**SUBMISSION OF RESPONSE**

**MR JEREMY FINNIS (FOR THE COLE FAMILY)**

Application Examination for TR010032 – Lower Thames Crossing  
Issue Specific Hearing 10 (ISH 10), Traffic & Transportation, Action Point 9

**UNIQUE REFERENCE:** LTC-AP1715

Drawing title  
**Proposed Walking, Cycling and Horse Riding Routes North of the River 1 of 2**

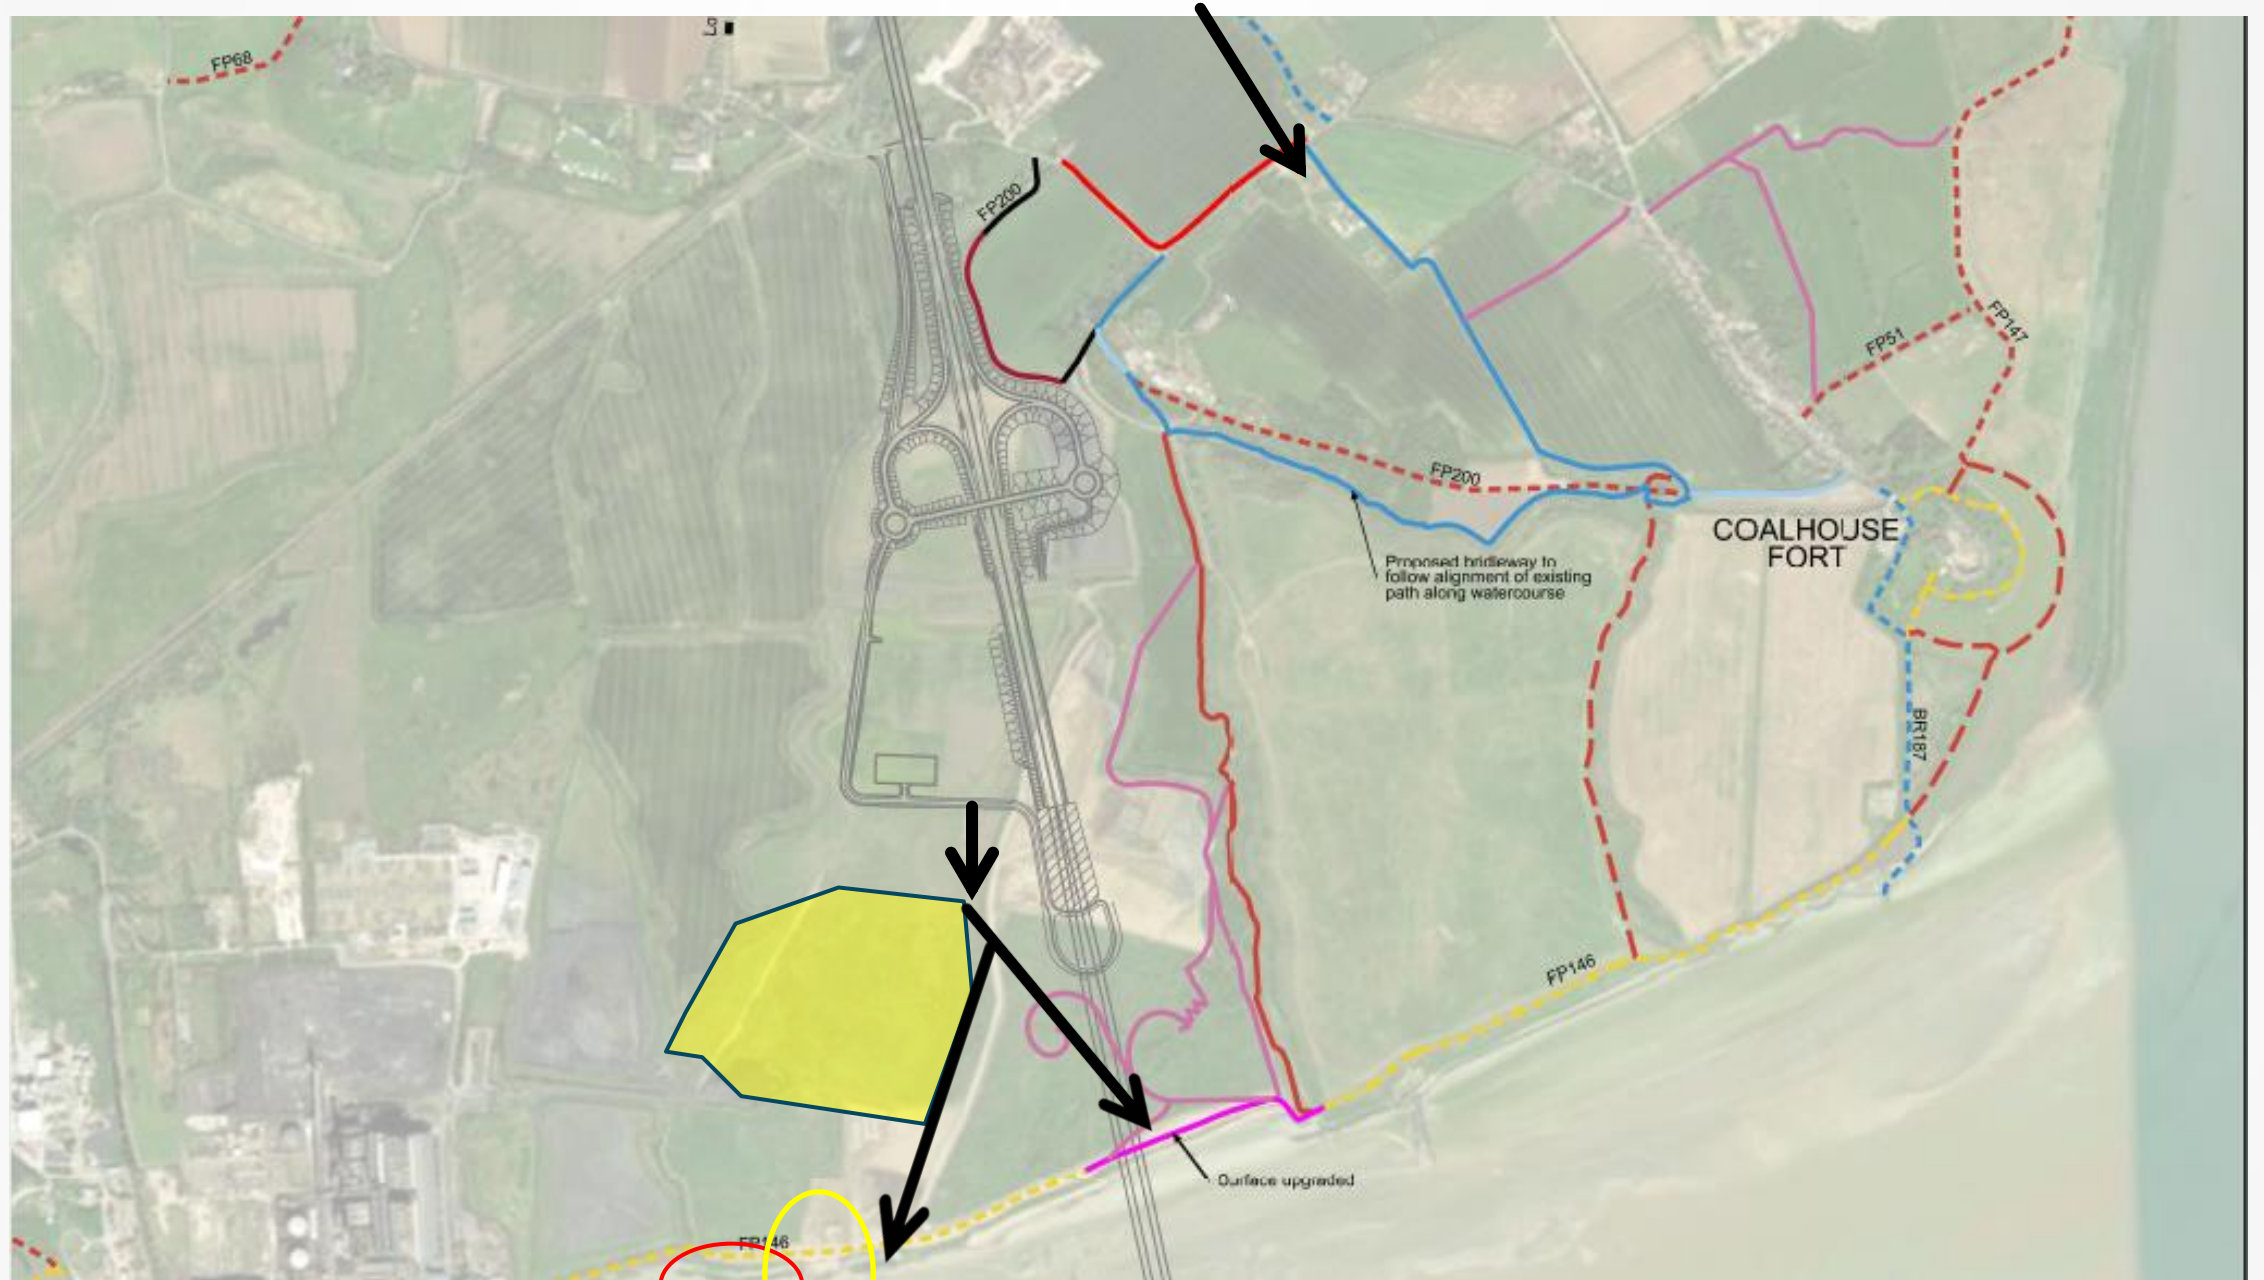
PROW – Bridleway (new)	From FP79 (redesignated as bridleway and	DR-AX00021 within Application Document 9.60 Supplementary Walking, Cycling and Horse	Figure 2 – Appendix 2	The Interested Party objects to the upgrading and redesignation of the existing public right of way which will direct further illegal activity and trespass onto their land. There is already a

diverted) to FP95 (redesignated as bridleway) to Brentwood Road	Riding (WCH) Maps (Volume B)		sufficient PROW network that runs south in to Chadwell St Mary and the addition of FP95 running due east to the Brentwood Road will cause significant increase in illegal activity on further land of the Interested Party. The new proposed route also would join Brentwood Road at a dangerous point as Brentwood Road is a busy highway and the crossing point would be at the bottom of a hill just as Brentwood Road bends due west. To have a Pegasus crossing at this point would be considered dangerous with vehicles accelerating around a lefthand bend as they leave Chadwell St. Mary just at the point of the proposed Pegasus crossing.
PROW – Footpath (redesignated as bridleway)	From Brentwood Road at FP78 to High House Lane	DR-AX00021 within Application Document 9.60 Supplementary Walking, Cycling and Horse Riding (WCH) Maps (Volume B)	Figure 2 – Appendix 2	<p>The Interested Party understands that High House Lane is highway land up to FP78 and thereafter as a private means of access. We understand that the Applicant is diverting this private means of access along the route of the proposed upgraded FP78.</p> <p>The junction of FP78 and the Brentwood Road is the main access point at which illegal activity enters the Farm on motorbikes and quadbikes and the upgrading of this to a bridleway will result in the inability for the private means of access to be securely gated. This would result in an excessive amount of illegal activity occurring from Chadwell St. Mary on to the Interested Party's land and conflicting with both the private means of access and the proposed horse riders. It is imperative that this diverted private means of access is secured, noting that the access needs to be of a sufficient width to accommodate articulated lorries. The interface of articulated lorries, farm traffic and other legitimate private use raises significant safety concerns. The result of upgrading it to a bridleway will make it impossible for the Interested Party to secure their boundaries.</p>
